Lower Thames Crossing

5.4.1.6 Draft Agreed Statement of Common Ground between (1) National Highways and (2) Natural England (Tracked changes version)

Planning Inspectorate Scheme Ref: TR010032
Application Document Ref: TR010032/APP/5.4.1.6

*Local Landscape Character Area boundaries of the Kent Downs AONB LCA, West Kent Downs, Sub-areas Cobham and Shorne*

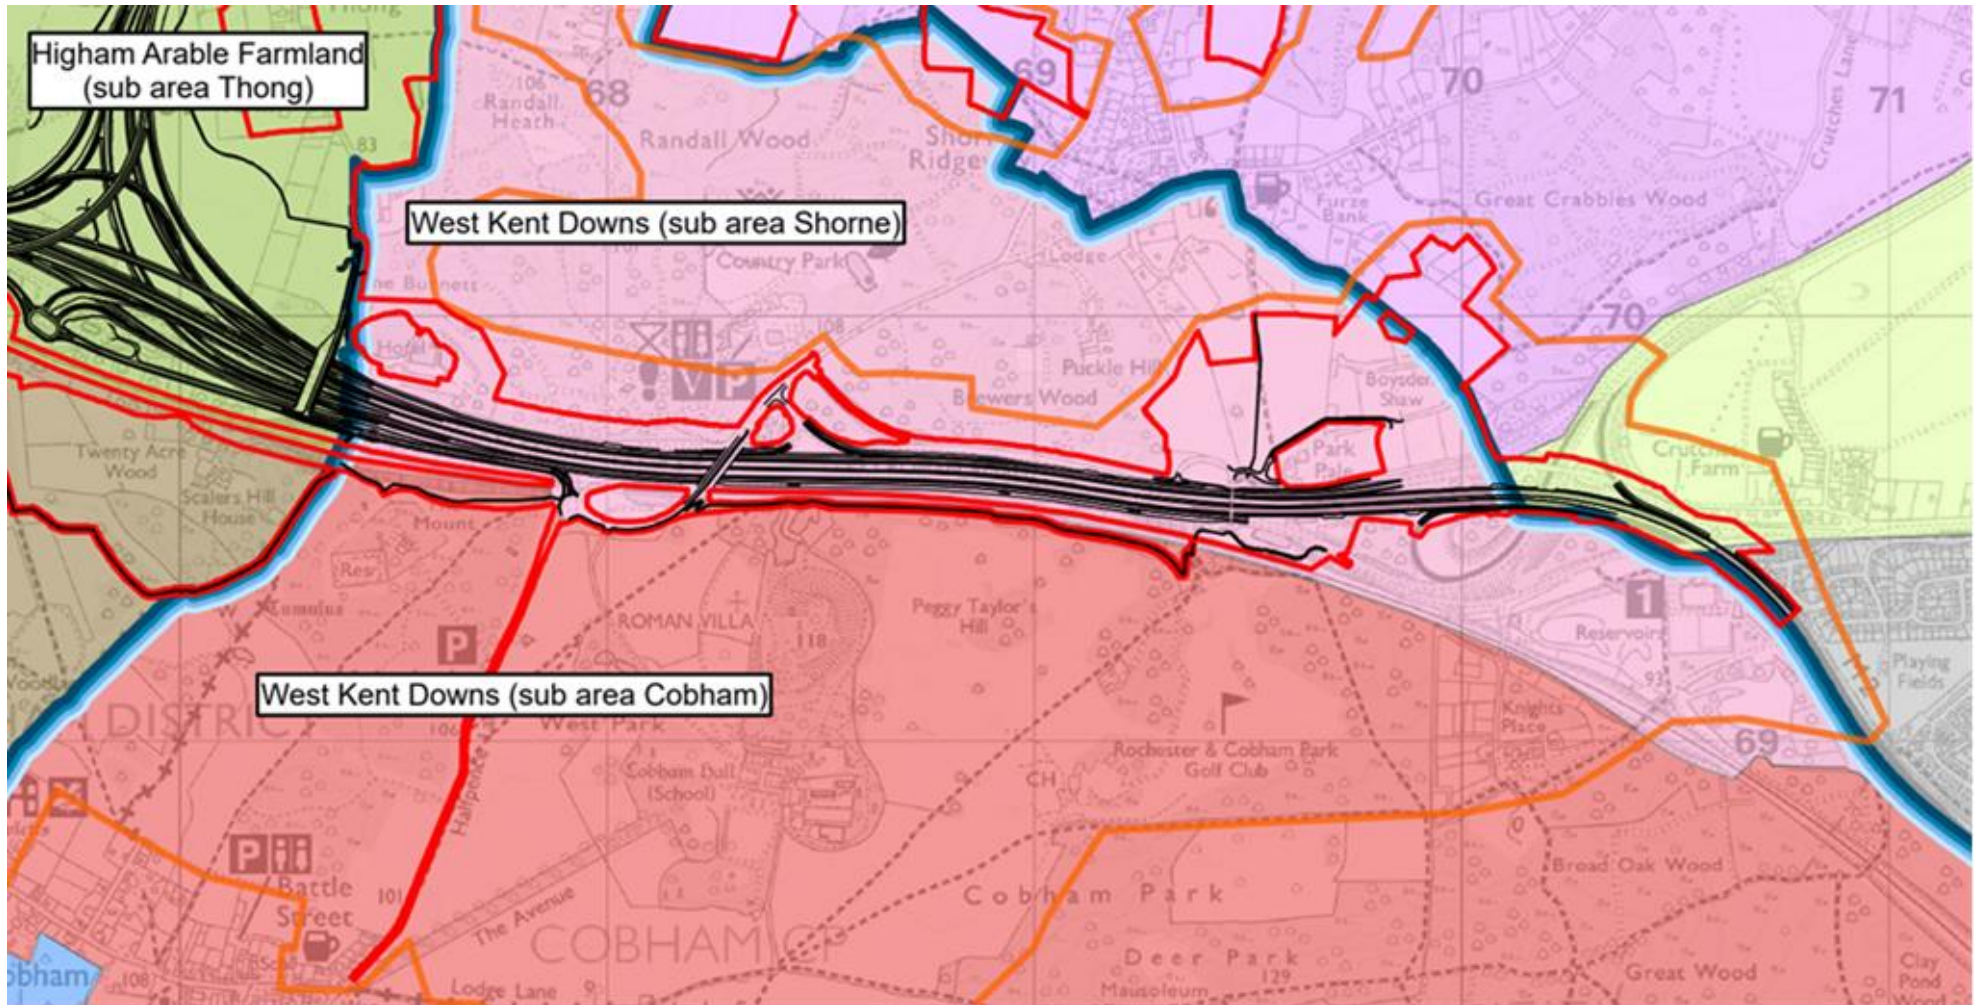
Landscape and visual					
Visual					
Baseline	2.1.105 WR (DL5)	The Environmental Statement appears to show incorrect boundaries for the contiguous West Kent Downs (sub area Cobham) and West Kent Downs (sub area Shorne) Local Landscape Character Areas (LLCA). The Cobham sub area boundary largely follows the northern boundary of the existing A2/High Speed 1 Rail Line alignment	The boundaries of the LLCAs within the Kent Downs AONB have not been incorrectly transposed. As detailed in Appendix A of Comments on Written Representations, the boundaries of character areas identified in the studies have been used to inform the definition of the LLCAs, which have been used as a basis for the assessment of effects on	ES Chapter 7: Landscape and Visual [APP-145] Comments on Written Representations Appendix A- Statutory	Matter Not Agreed
